From: [REDACTED]
To: [Norfolk Vanguard](#)
Subject: Issue Specific Hearing on On-Shore Environmental Matters
Date: 14 January 2019 13:40:08

Re: Issue Specific Hearing on On-Shore Environmental Matters to be held on 5-2-19.
My Registration Identification No. 20012530.

Would you please take into account all the items I raised on my previous submission to you. In addition I wish to raise the following for consideration with particular regard to the onshore substation site at Necton:

Indicative Onshore Project Substation
Mitigation Planting - Norfolk Vanguard

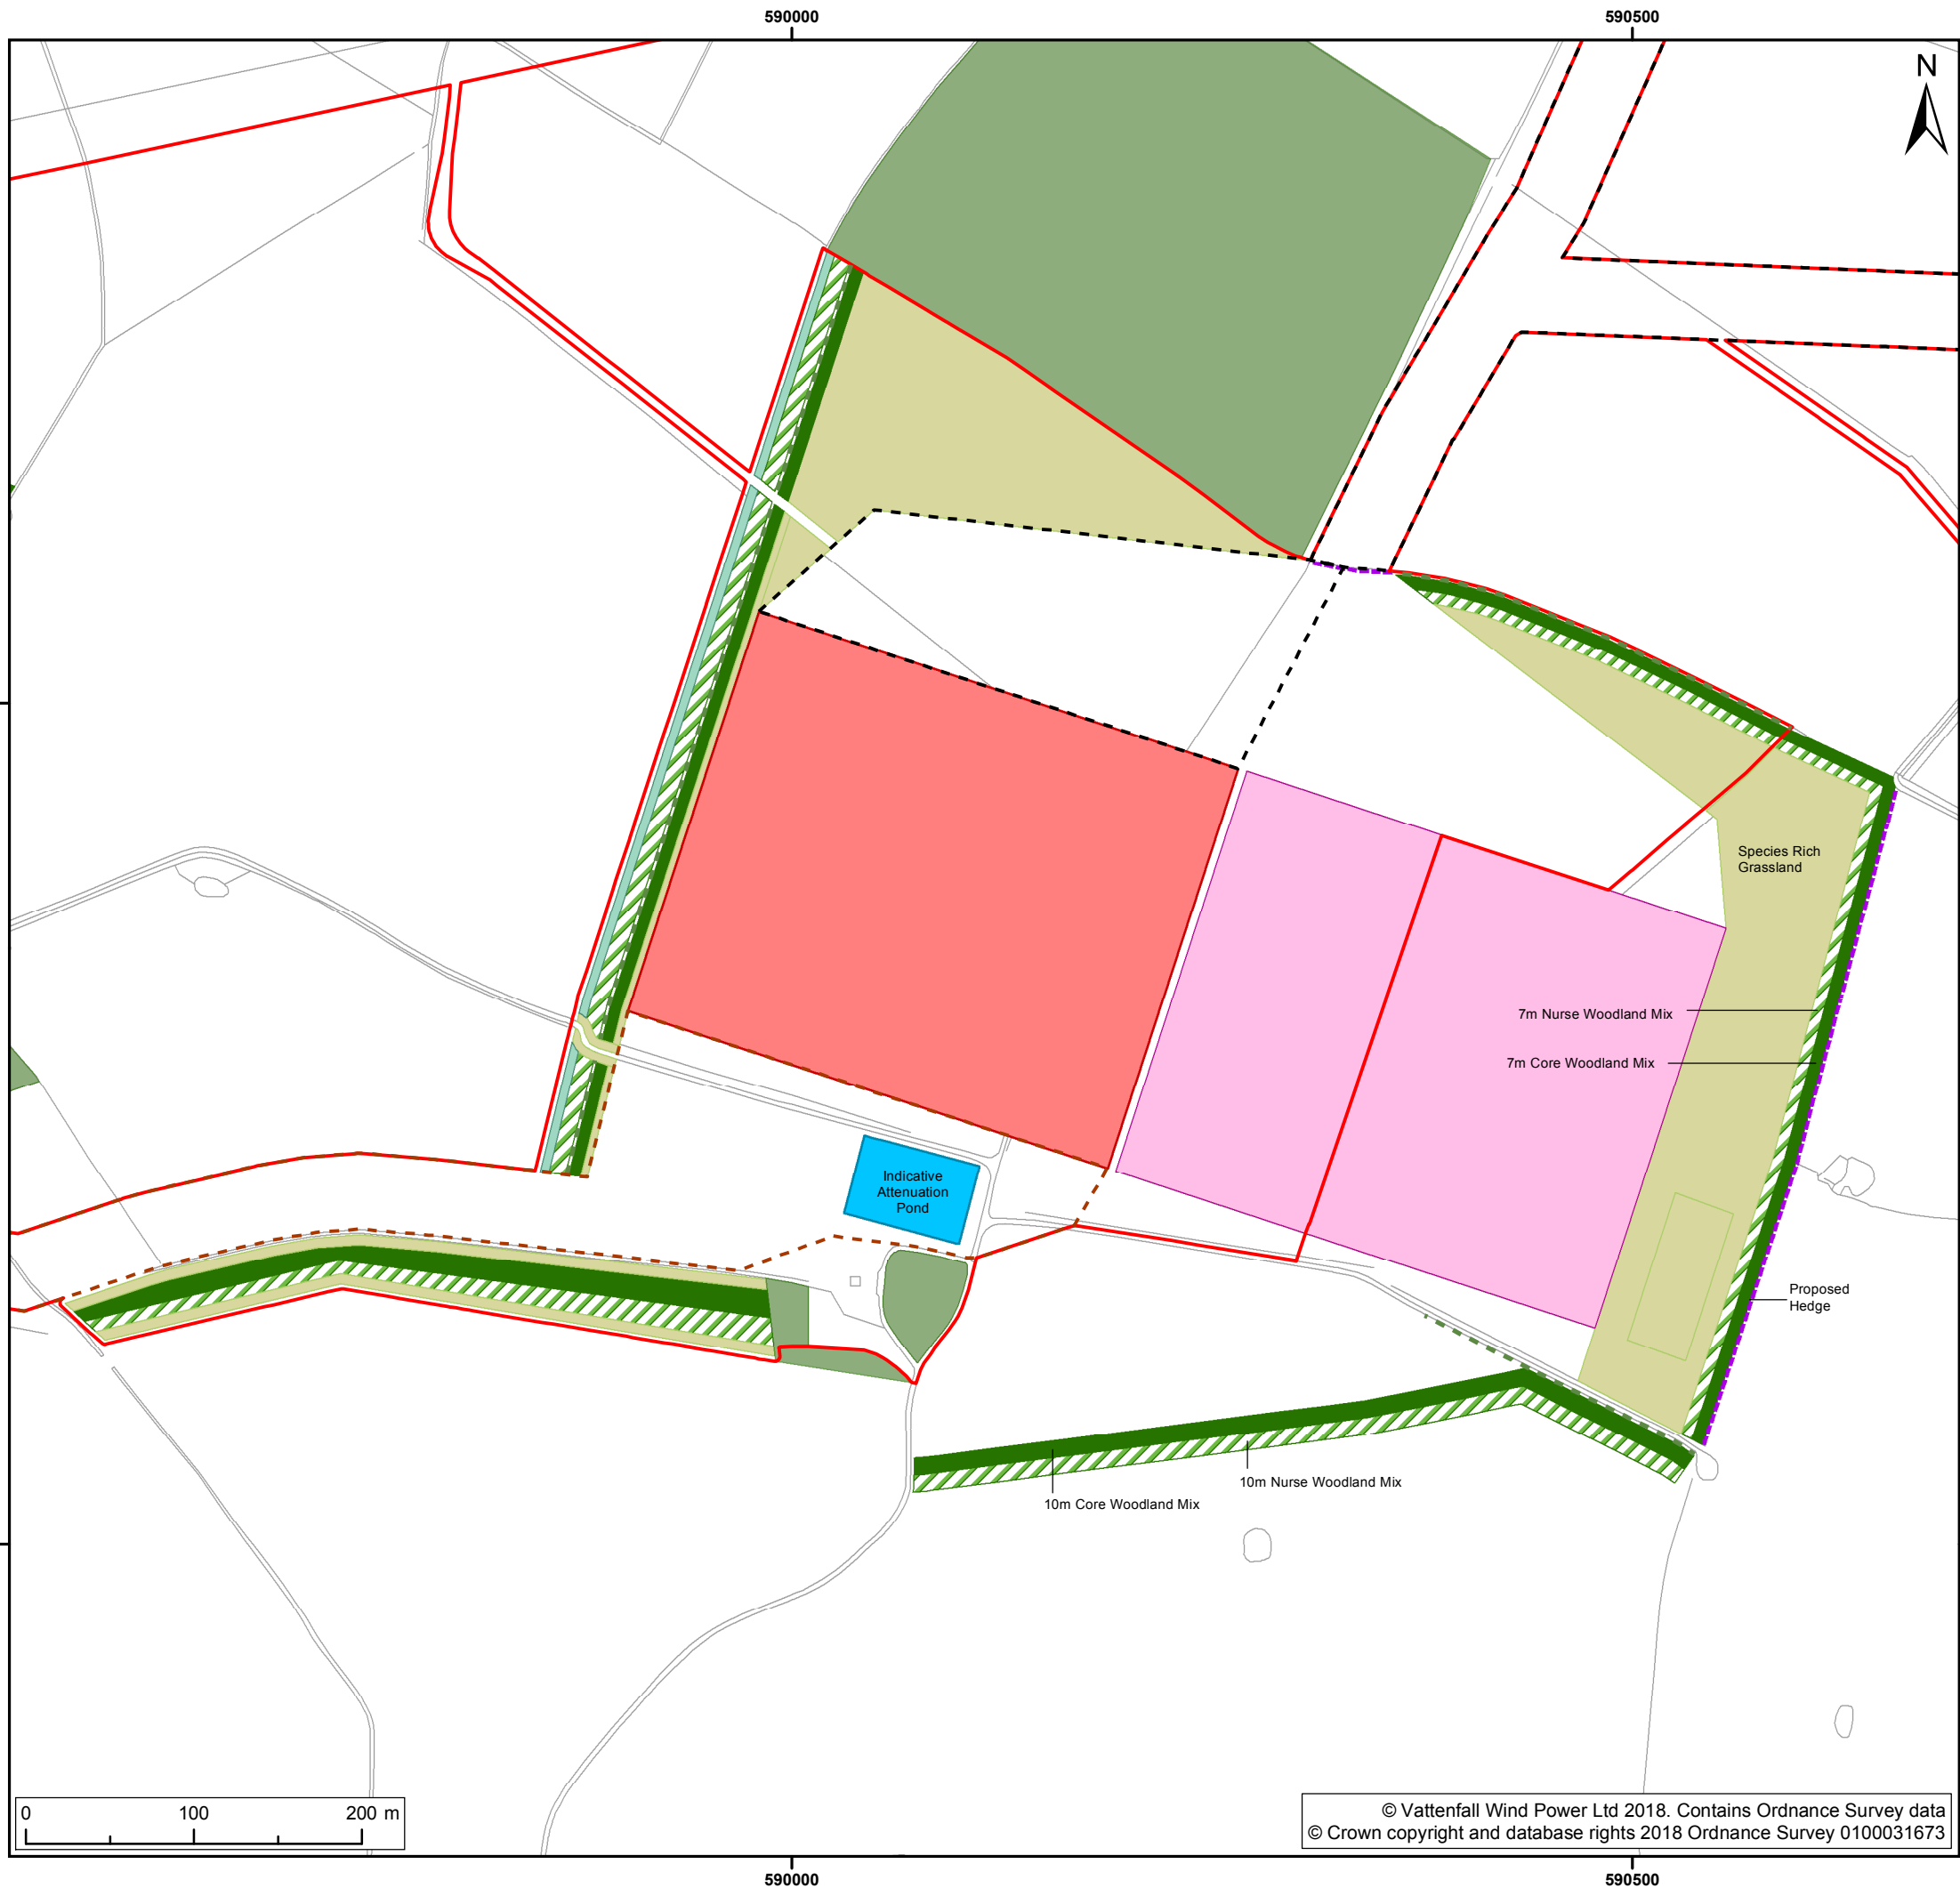
2. Vattenfall Peir Documents state that 1km of hedging will need to be removed at the construction site of the Onshore Substation at Necton. Mitigation planting will not replace the environmental loss of the existing mature hedges and will make a significant impact on the local animal life.
